WHIPPLE-CALLENDER ARCHITECTS

RE: LIBERTY BAY RECOVERY CENTER, 343 FOREST AVENUE- CONSULTANT RESPONSE TO LEVEL 2 STAFF REVIEW. CONSULTANT RESPONSES IN CAPS

Final Plan for Planning Board Review: Staff Review Comments

COURTYARD PLAN

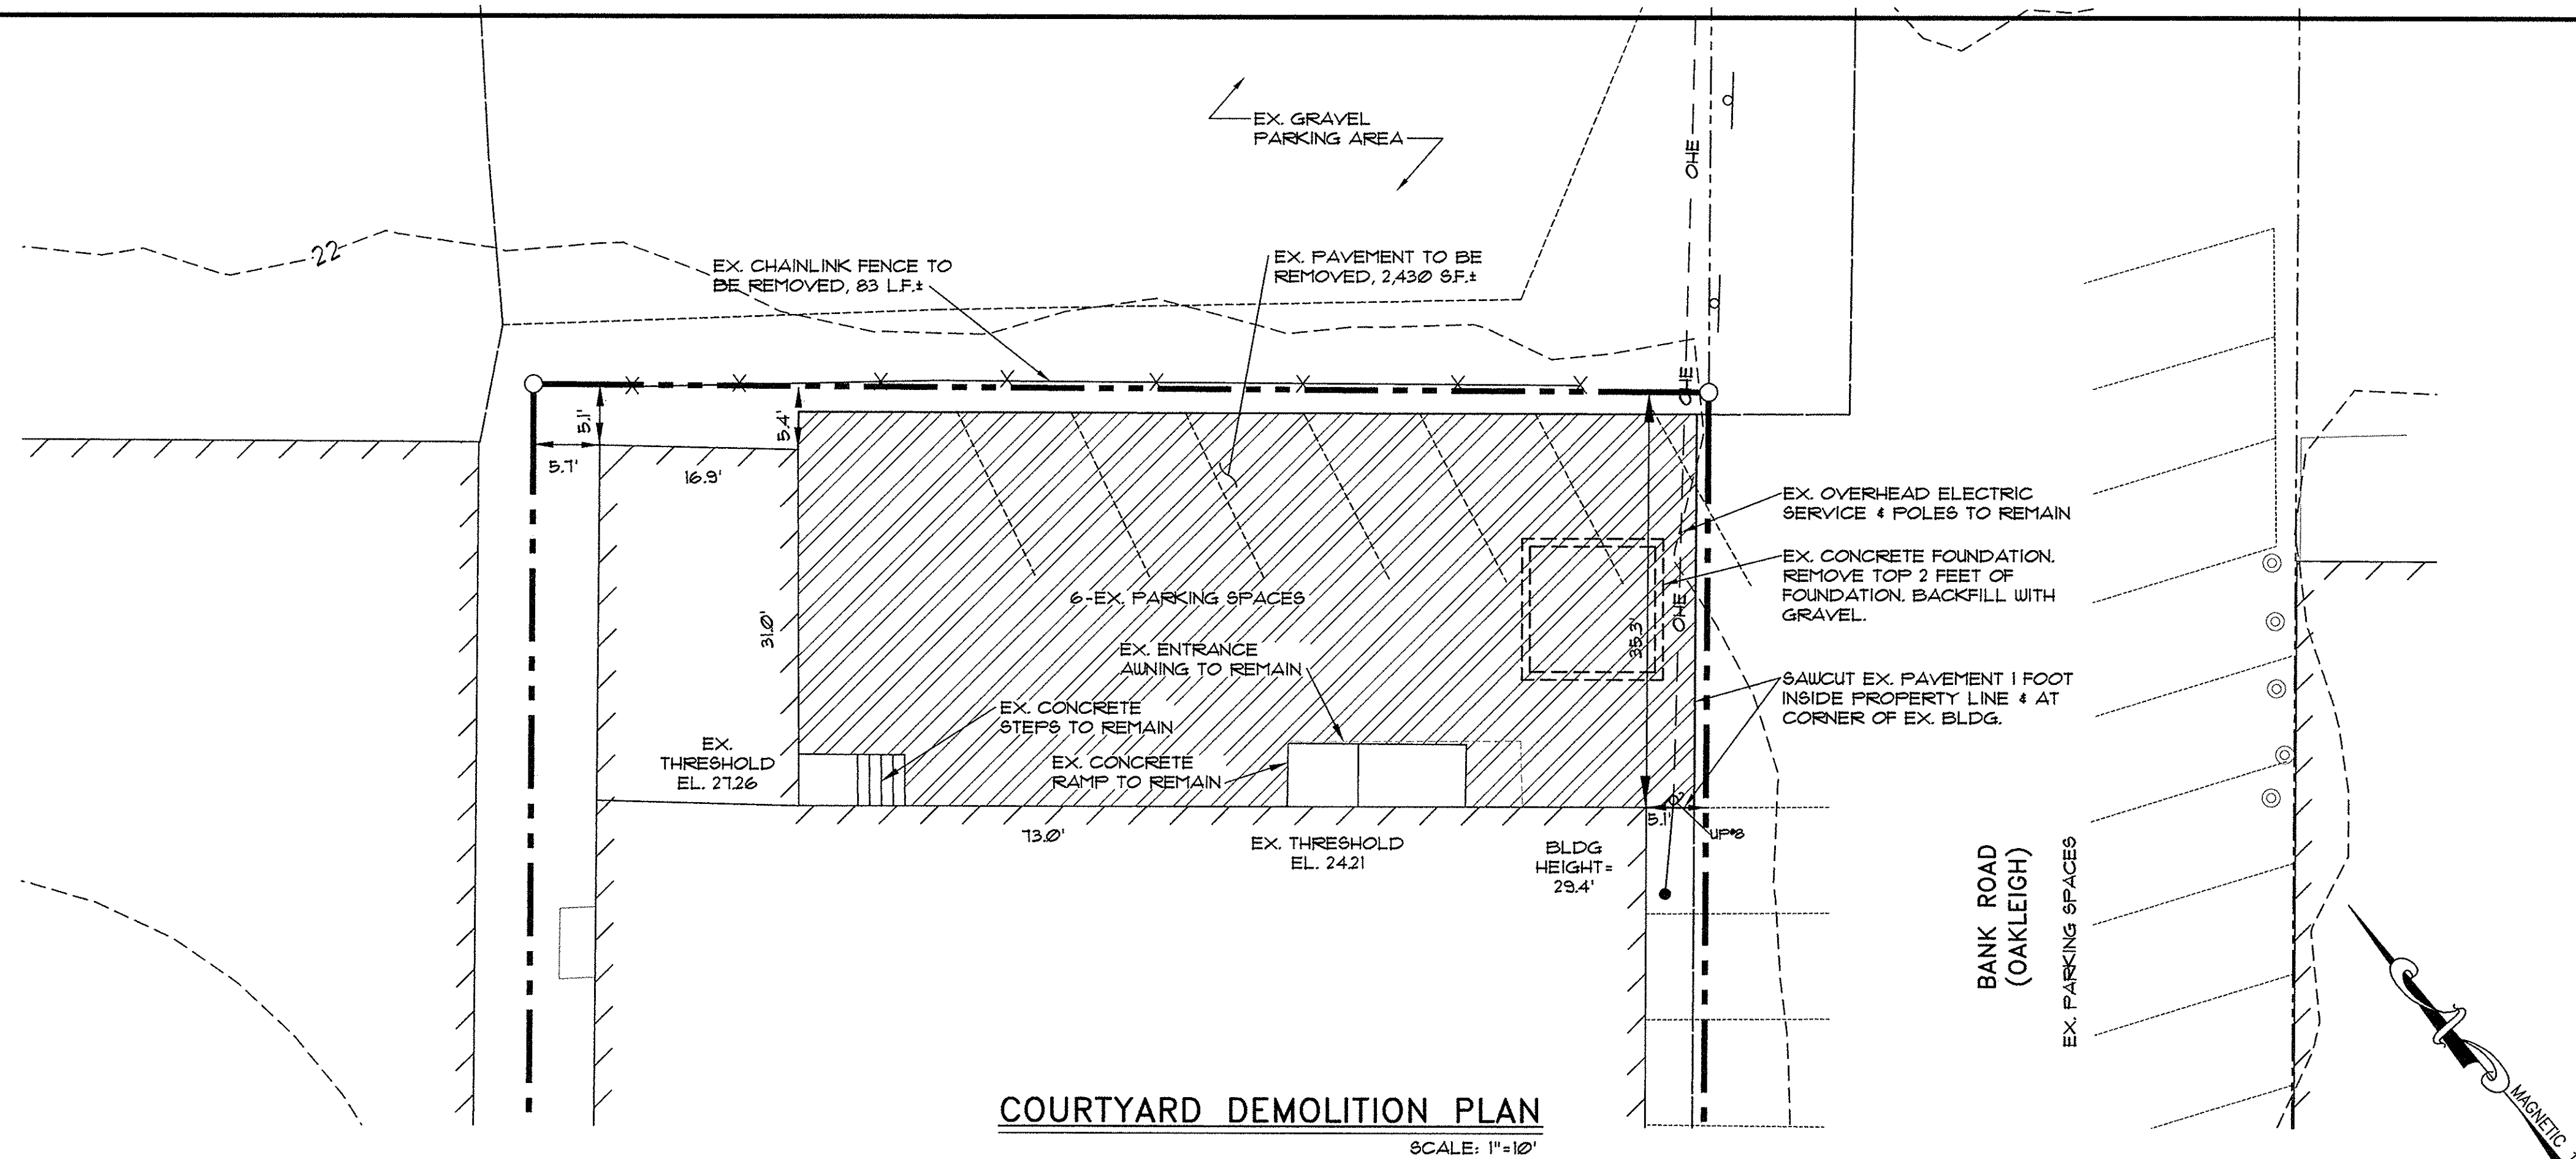
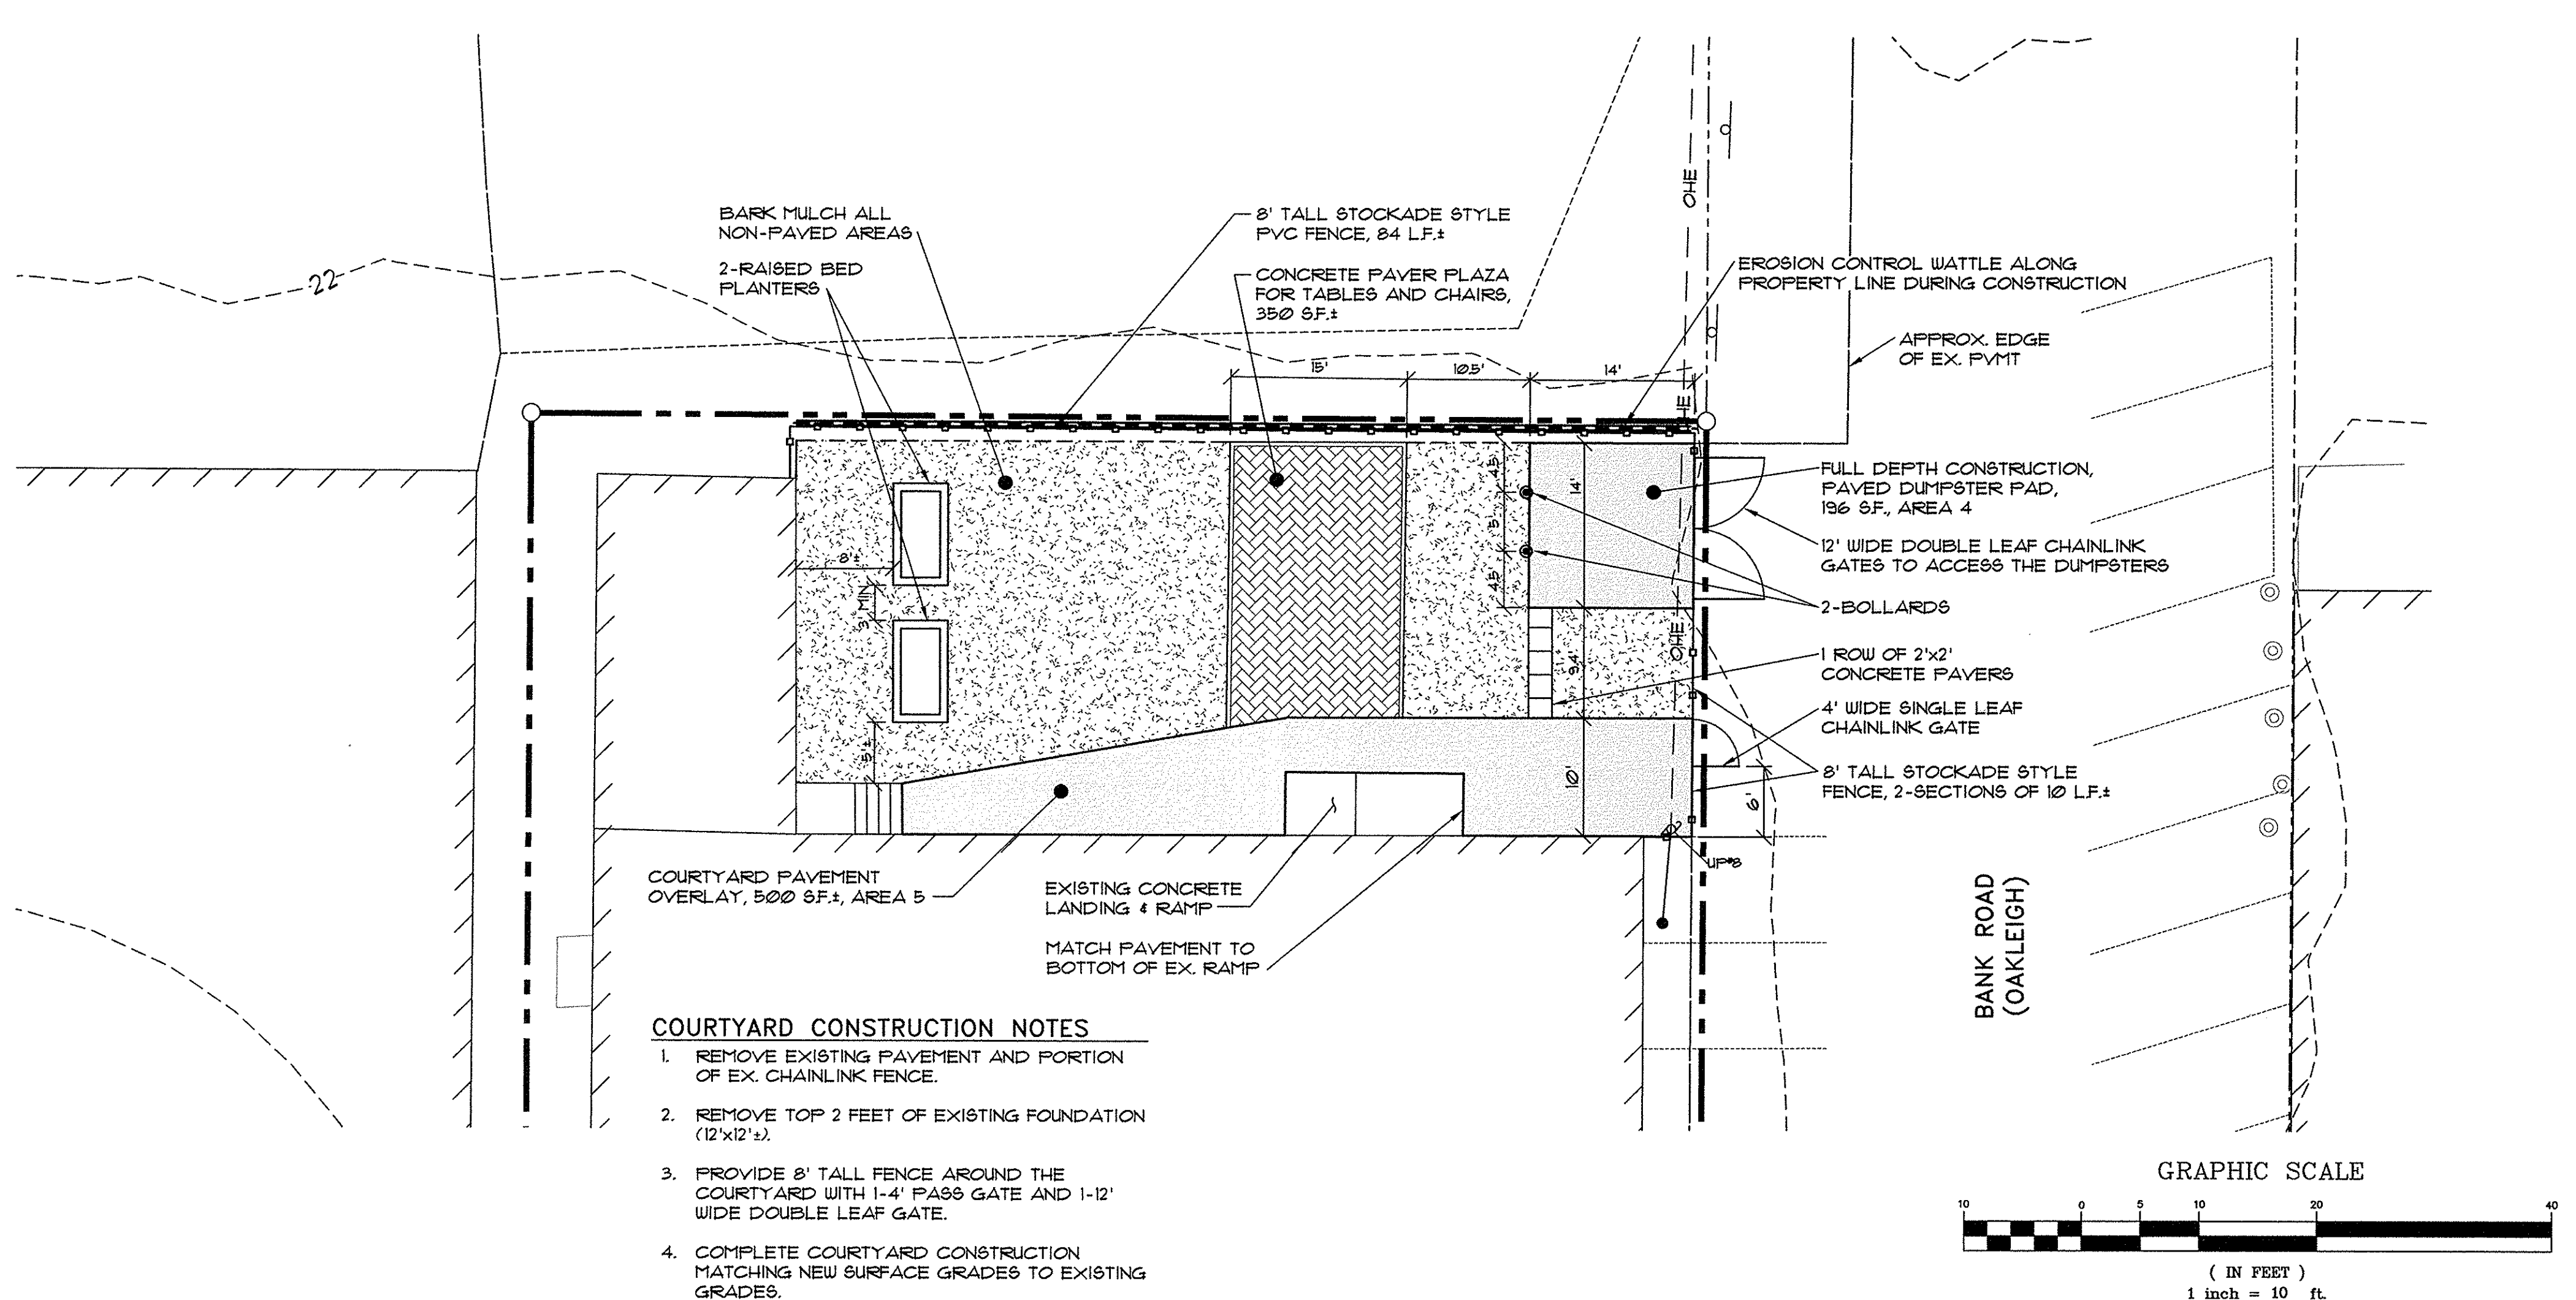
6. Note – If exterior lighting is provided, fixtures shall be full-cutoff and in full compliance with Section 12 of the Technical Manual. N.A.
7. Clearly indicate on applicable plan sheets a boundary line within which site work will be occurring. PLEASE REFER TO REVISED SITE PLAN

7. Of the parking spaces shown, which are allotted for this particular user? This should be clearly delineated within the submitted plans. PLEASE REFER TO REVISED SITE PLAN

7 CATCH BASIN PROTECTION NOT TO SCALE

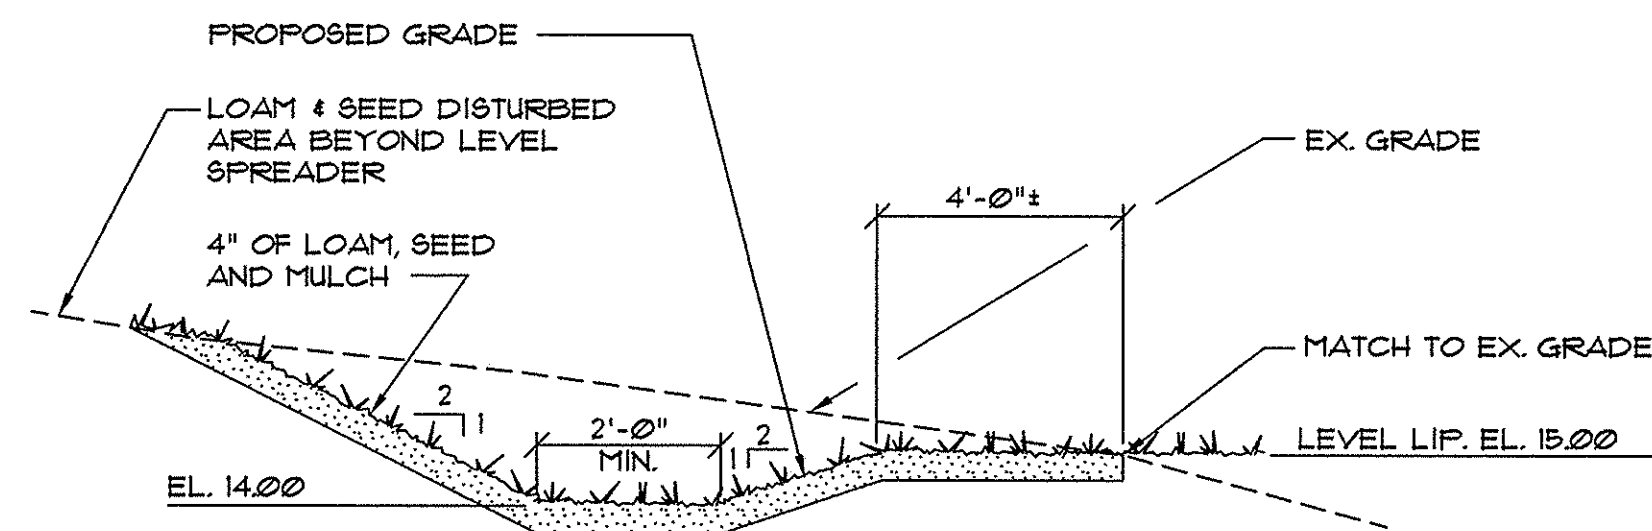
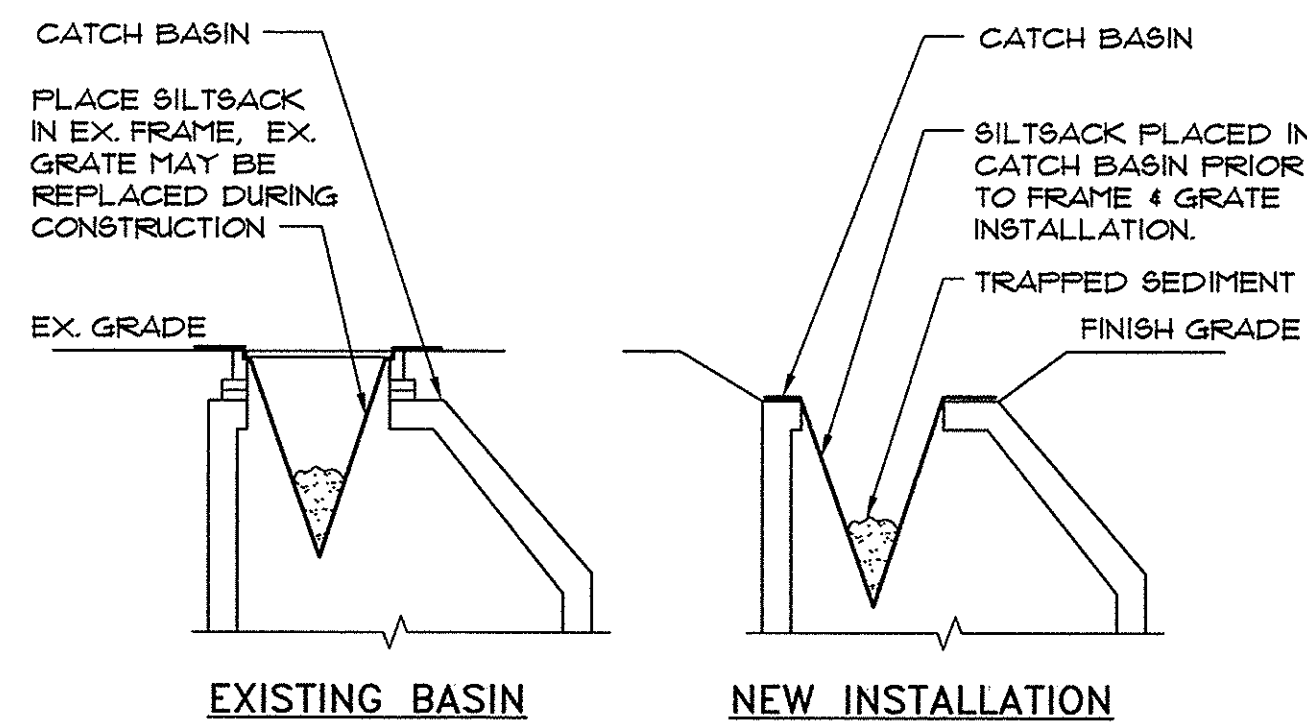
- a. Basic Standard: Plans, notes, and details should be provided to address erosion and sediment control requirements, inspection and maintenance requirements, and good housekeeping practices in accordance with Appendix A, B, & C of Maine DEP Chapter 500. PLEASE REFER TO ATTACHED PLAN FOR EROSION AND SEDIMENT CONTROL DETAILS.
